# Fosse Green Energy

EN010154

24 March 2026

#### **8.4 Statement of Common Ground with Historic England**

Fosse Green Energy - Solar Farm
Viewpoint 35: View south-east from Grange Cottage

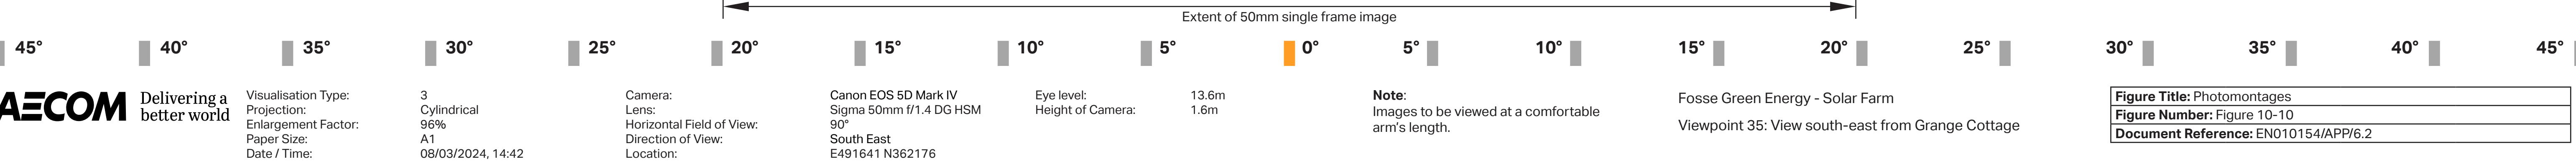
4.1.10	Potential impact of the Proposed Development on views toward Aubourn, specifically views towards the Grade II Listed medieval Old Church and Grange Cottage.	HE considers that removal of panels from 'Field 46' would reduce the adverse effects on proximal heritage assets including the rural context and experience of the village of Aubourn (specifically kinetic views on approach from the south), views towards the medieval Old Church (Grade II listed), and the non-designated heritage asset Grange Cottage.	<b>Appendix 7-D Detailed Heritage Asset Setting Assessment</b> of the <b>ES [APP-127]</b> concludes that the Proposed Development will result in less than substantial harm (lower end) to the heritage significance of the Grade II Listed Grange Cottage (NHLE 1061951) and no harm to Old Church (NHLE 1360538). After submission of the ES documents, an in-person meeting to discuss the layout of the Proposed Development in proximity to Grange Cottage and heritage assets at Aubourn was held on site on 15 September 2025. In response to HE's (as well as other stakeholders') concerns regarding the proximity of solar PV to Grange Cottage and heritage assets at Aubourn, the Proposed Development design has been amended to remove panels from the field immediately south-east of Grange Cottage (i.e. Field 46). This is secured via the <b>Works Plans [AS-105]</b> that were updated and submitted to the Examination as part	Agreed
